## **Application: SSI 7485**

I write regarding the proposed modification to M4-M5 Link, Mod 2 The Crescent overpass and changes to pedestrian infrastructure in North Annandale, Rozelle and Rozelle Bay Foreshore area.

Figure 4-2 Pedestrian and cyclist bridge infrastructure options

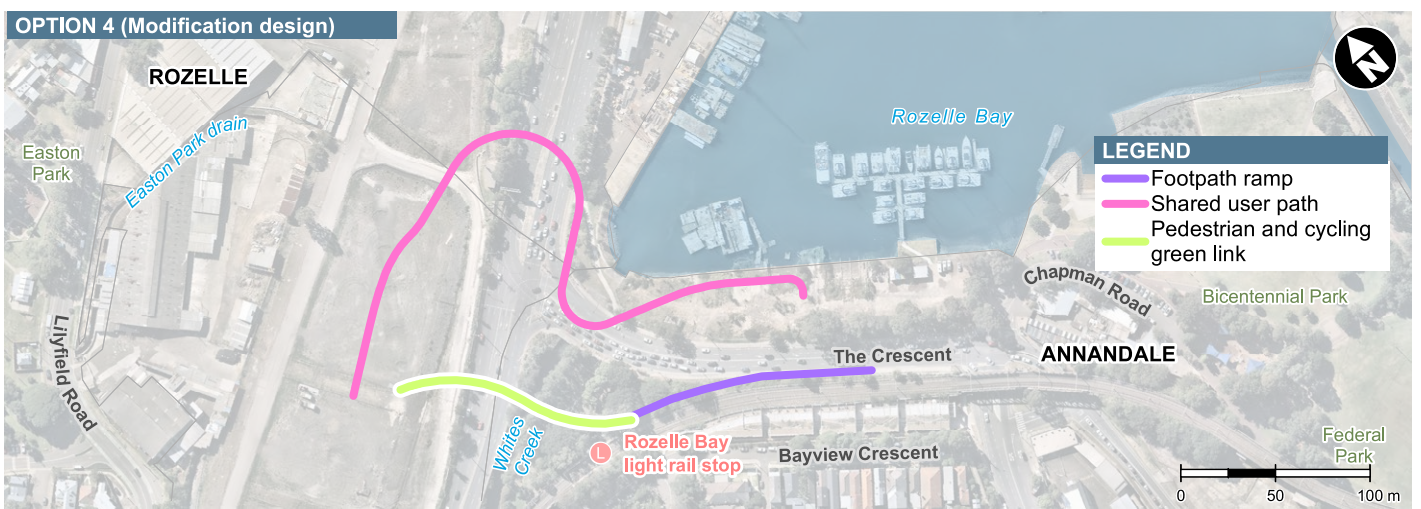
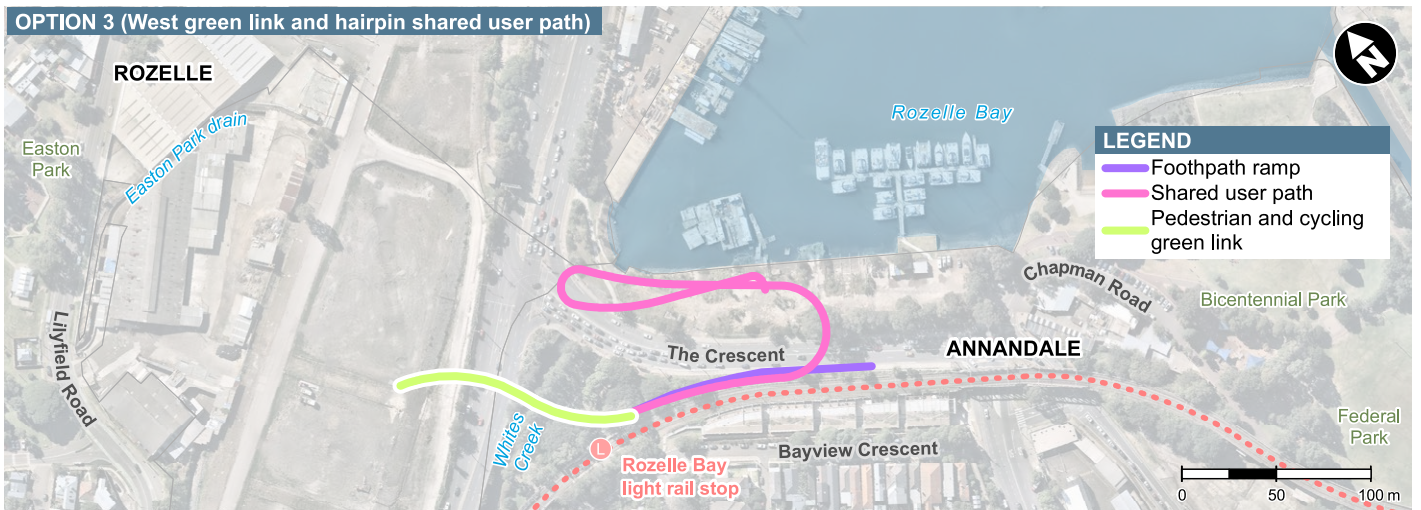
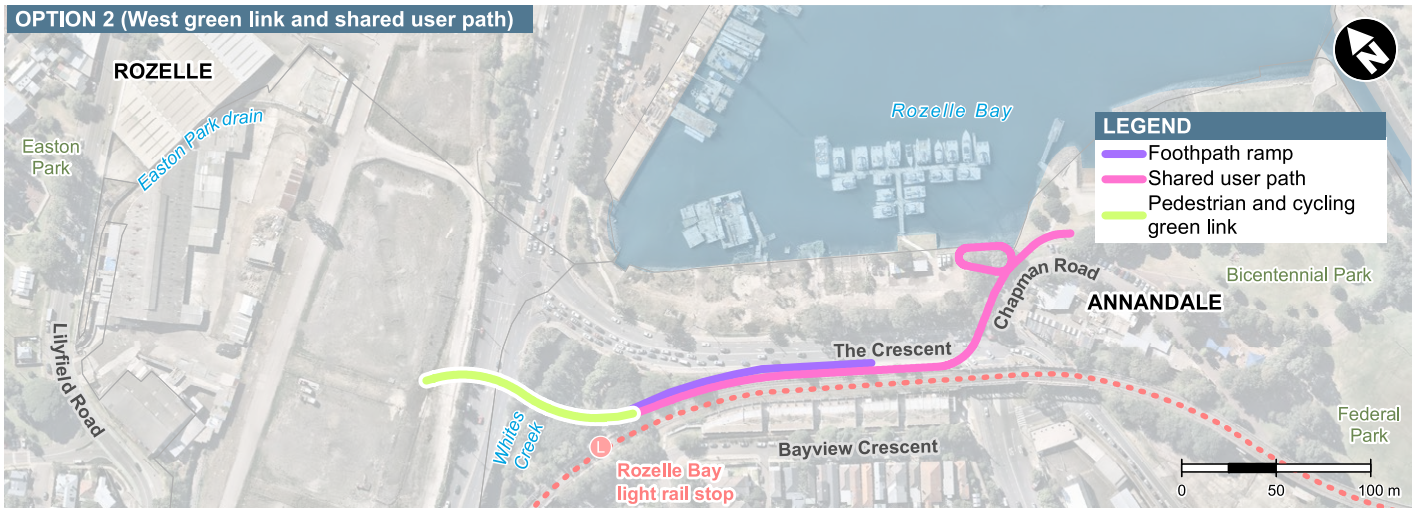
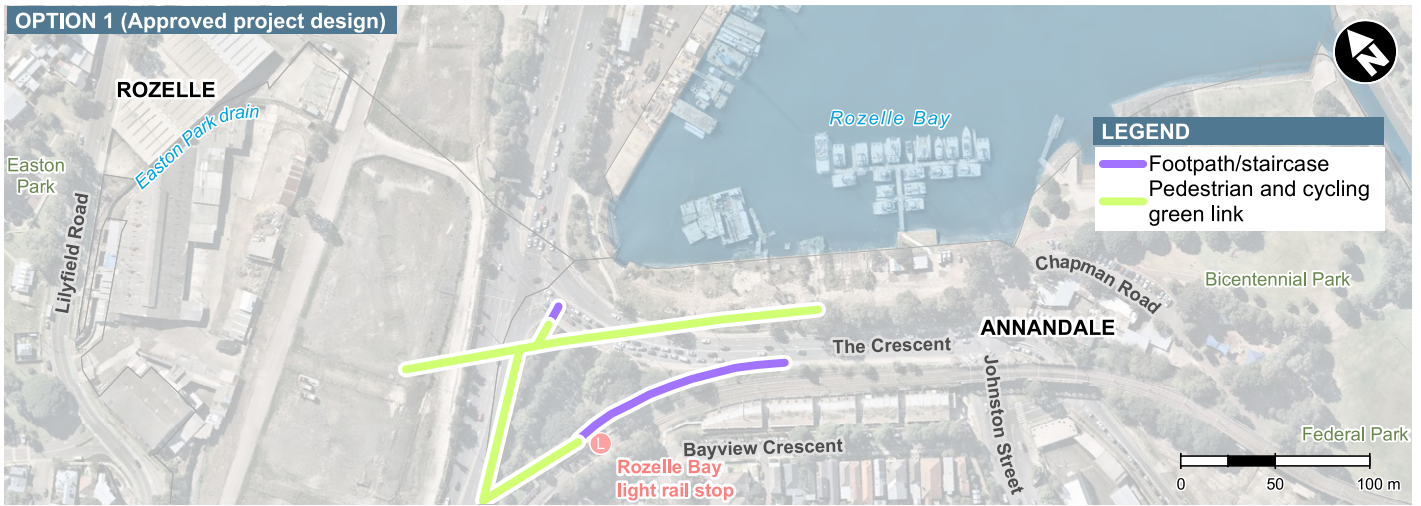
- The significantly reduced safety and increased risk for pedestrians and cyclists with removed access over The Crescent to Bicentennial Park and the increased traffic along Johnson Street.
- Being required to cross five sets of pedestrian lights at The Crescent as my option to reach the foreshore from Annandale or from Rozelle light rail stop.
- Removal of direct active links to the foreshore, cutting the community off from the area and the proposed revitalisation of the entire Bays Precinct, including linking the Light Rail and Bus stops to a Ferry wharf and Metro station.
- Urban and landscape design that is being built before a finalised Masterplan for the area.
- Traffic changes that limit movements around the suburb and create further congestion in the local streets of Annandale, Forest Lodge, Glebe, Lilyfield and Rozelle with no planning to deal with these.

- Provide pedestrian and cyclist paths that maximise people safety and do not force us onto busier streets, unsafe concrete plazas and caged walkways.
- Integrate active and direct connections to all active transport – including the future Metro West and Foreshore Ferry Wharf.

Figure 4-4 Elevation: Indicative view of The Crescent overpass

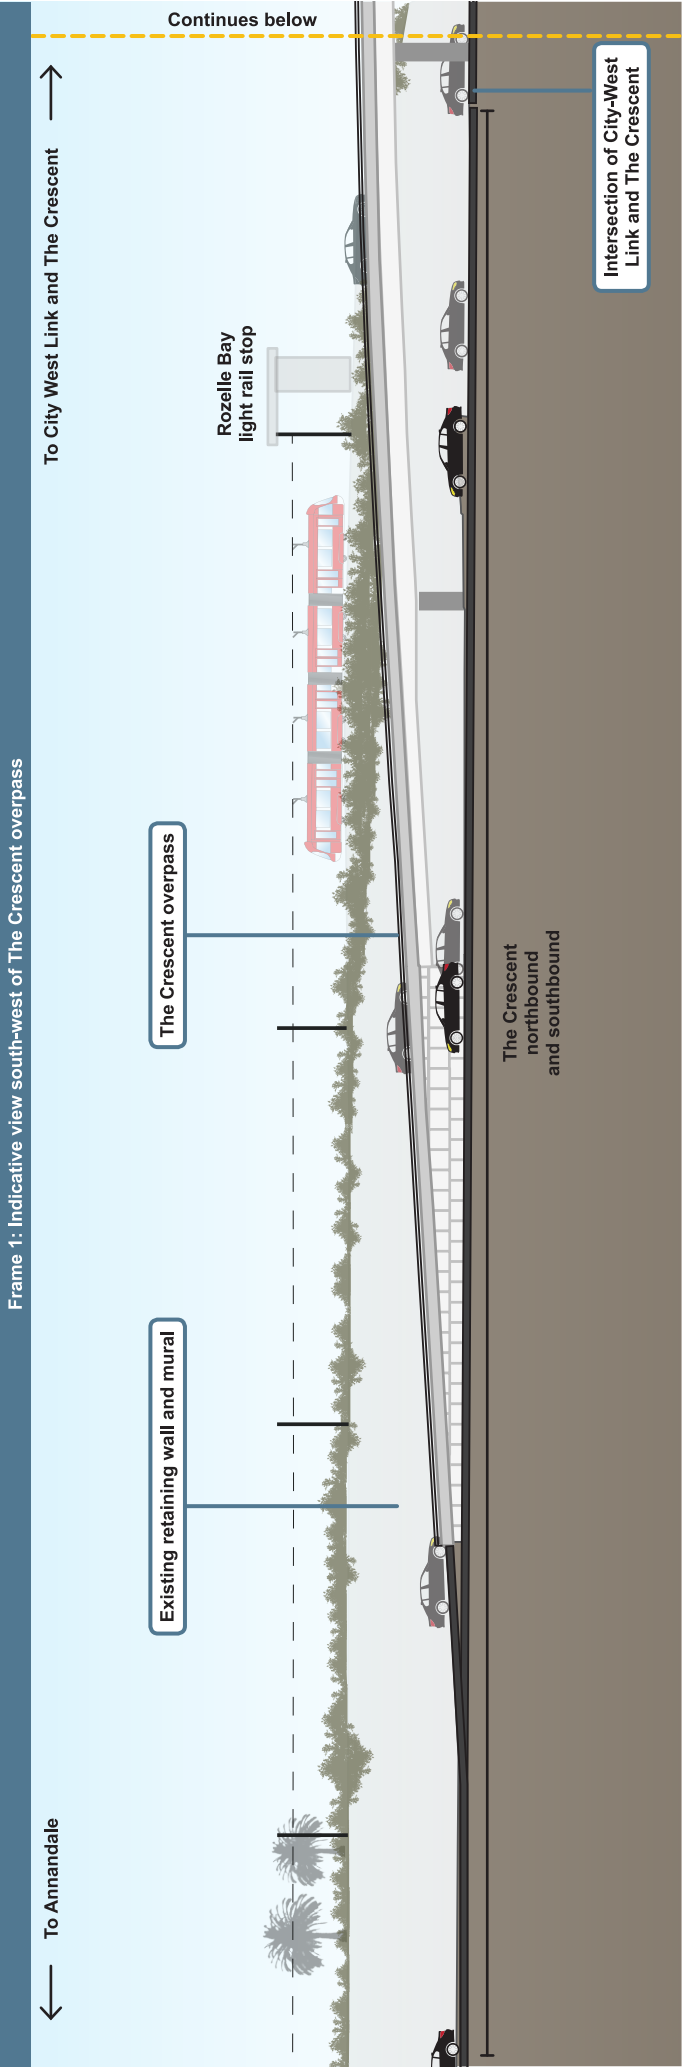
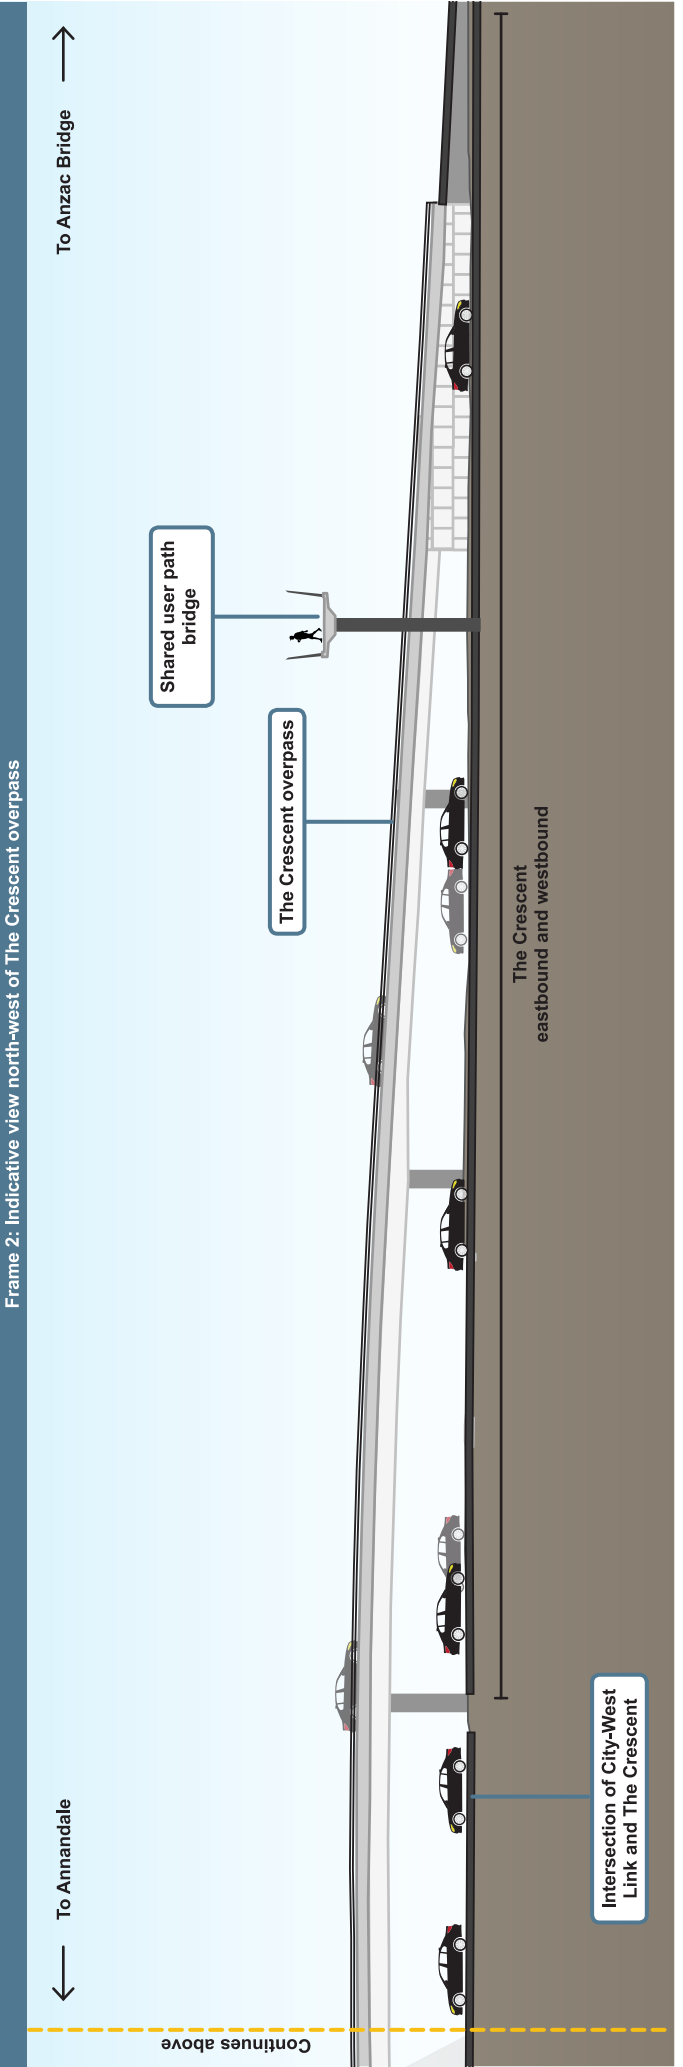
I request RMS work with the community to explore alternate design options to the proposed new car overpass design and the changed pedestrian and cyclist links. I am seeking the reinstatement of the safe, direct access from the approved EIS GreenLink to create a continuous green open space connection from the Rozelle Rail yards and Annandale to the foreshore. The GreenLink was more than just a walk way - it put people central to the design, maximising safety, and providing much needed accessible open space for the community now and into the future Bays Precinct design.

Figure 4-6 Elevation: Indicative view of Rozelle Rail Yards Pedestrian and Cycling Green Link

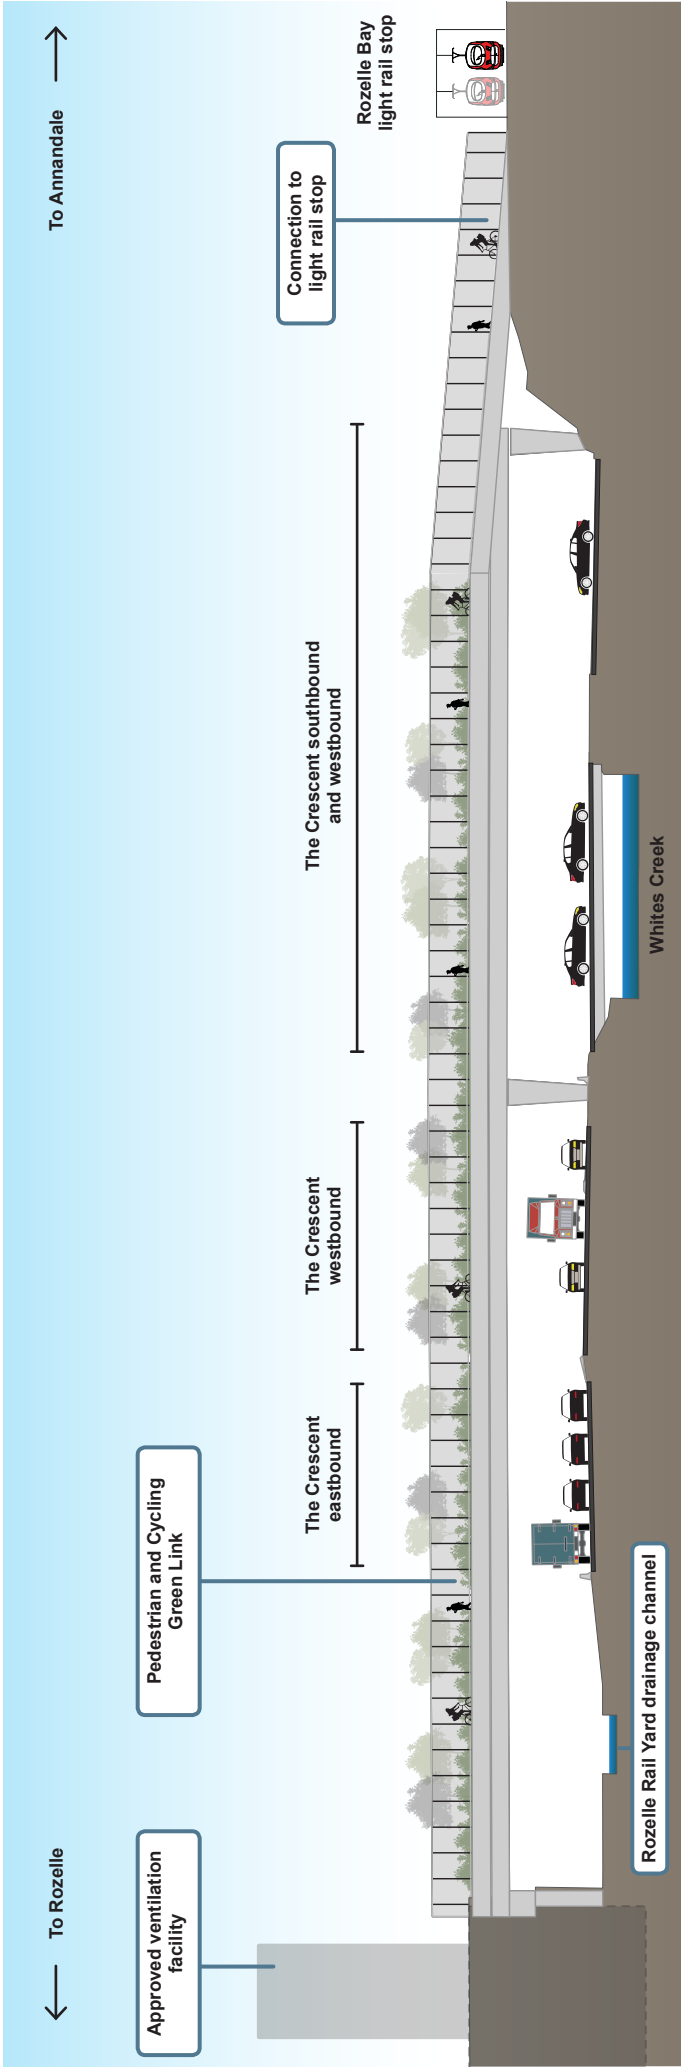
- Reinstatement of the GreenLink connecting communities and green open space from Rozelle to Bicentennial Park.
- Relocate and design pedestrian and cyclist connections that are continuous, safe and direct.
- Design the modification infrastructure and active links in response to the character of the suburbs, the location of the foreshore and its potential future development.
